KCH Engineering Solutions, LLC

Re: McGehee Tract PCD No. SF 2111

The following is a summary of the items that were addressed based on the "redline" comments that were received from El Paso County on June 28, 2021.

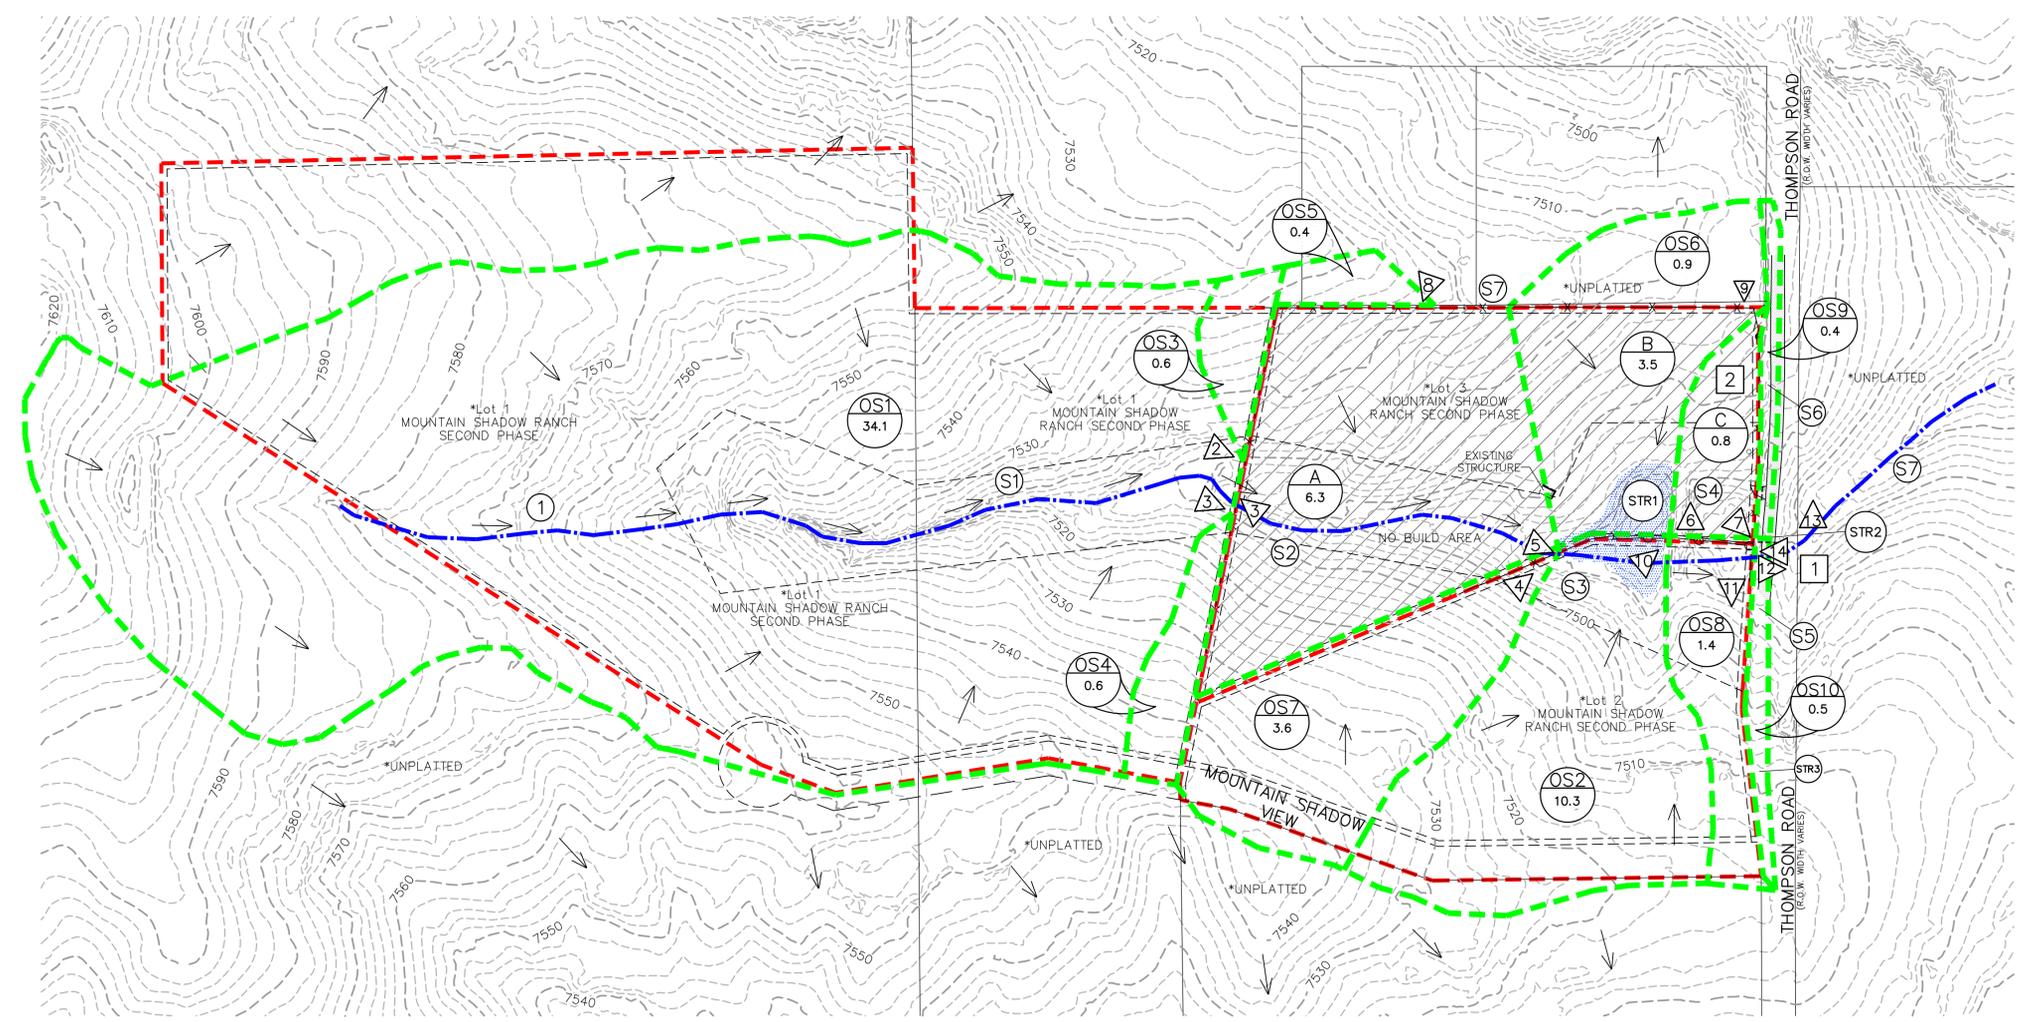
Existing Conditions Drainage Map

1. The "Design Point Summary" table indicates runoff from each sub basin **individually** and not **cumulatively**. A cumulative table was added to both drainage maps.
2. One of the design points along the west property line was changed from Design Point 3 to Design Point 1.
3. The hatching was limited to only the "no build area" located along the main swale.

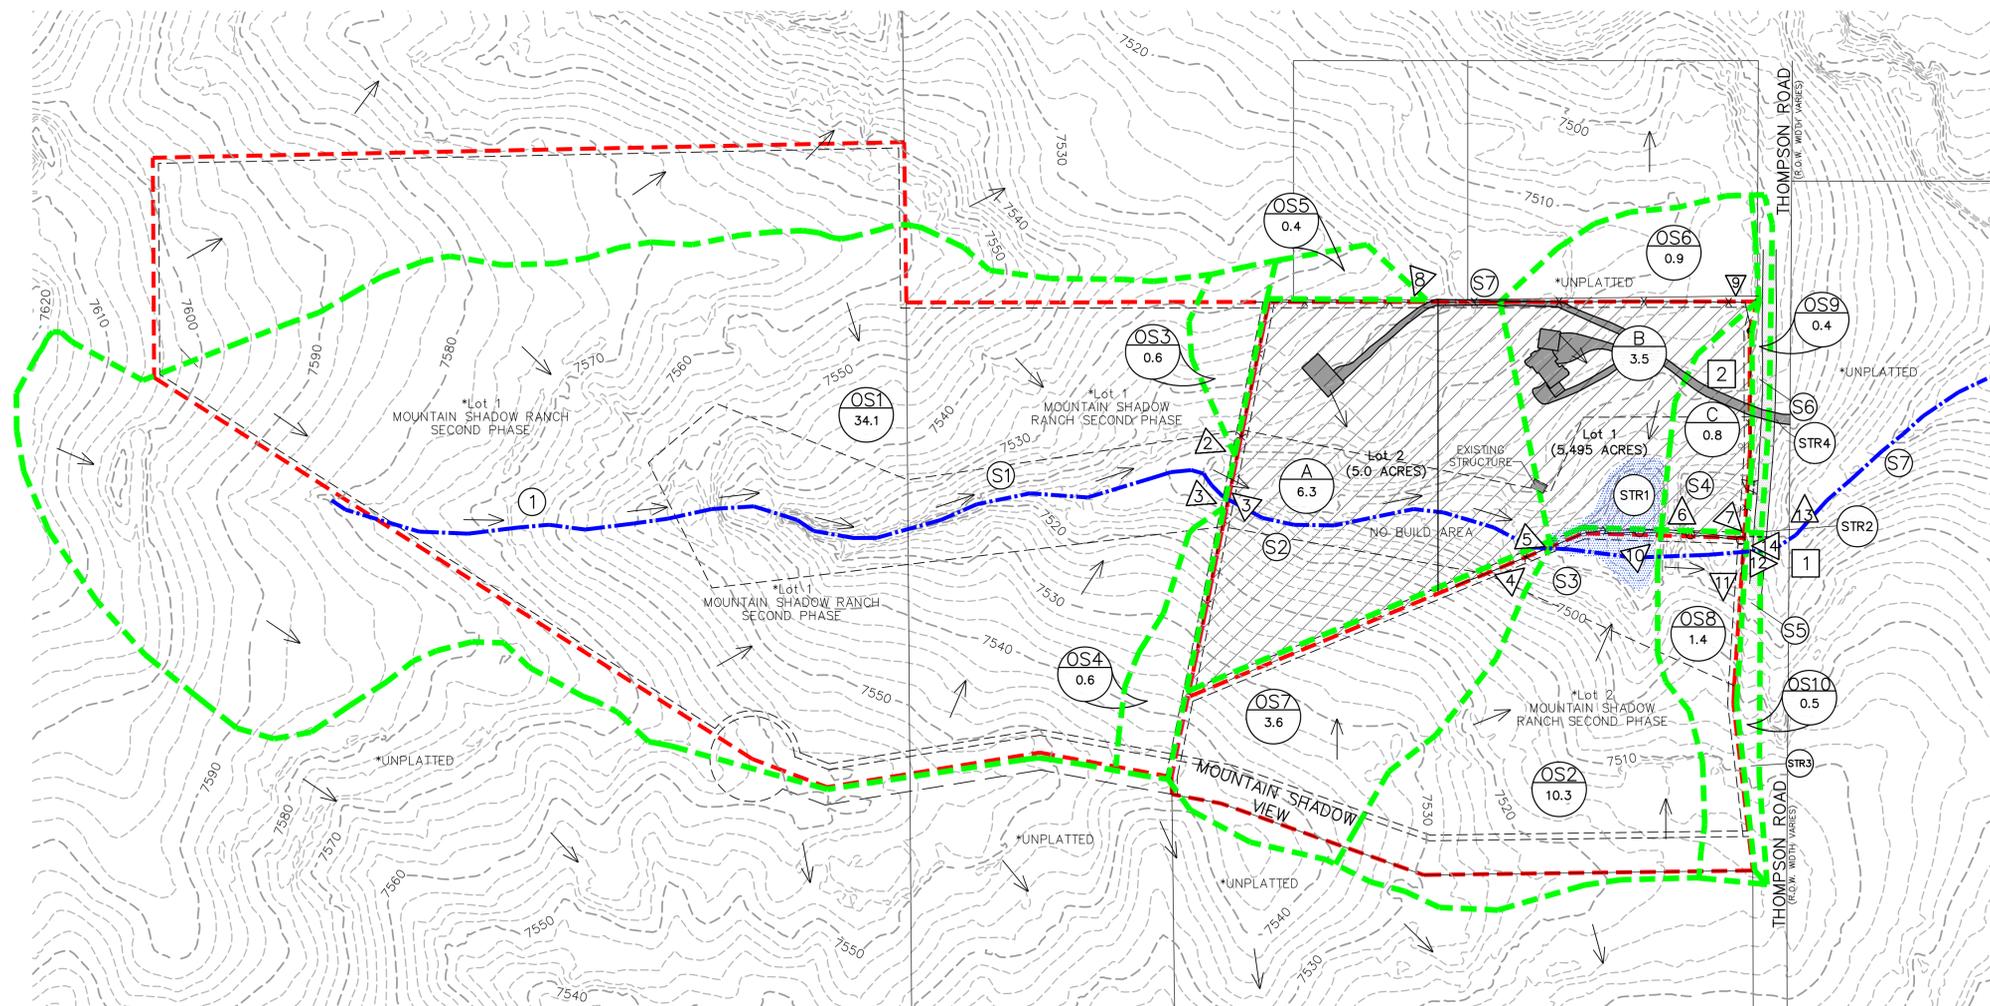
Developed Conditions Drainage Map

1. The swale IDs on the first column of the Swale Summary table were changed to S1, S2, S3, etc.
2. The circle with the numeral 1 was deleted.
3. The swale located east of Thompson Road was changed to S8 (Swale 8) due to a duplication of S7.
4. Sub basins OS9 and OS10 were hashed to show "no build areas" even though the majority of the sub basin areas are located inside the Thompson Road right of way where no building can take place. Any of the remaining sub basin area to the west of the Thompson Road right-of-way are located in the set-back where building is not permitted.
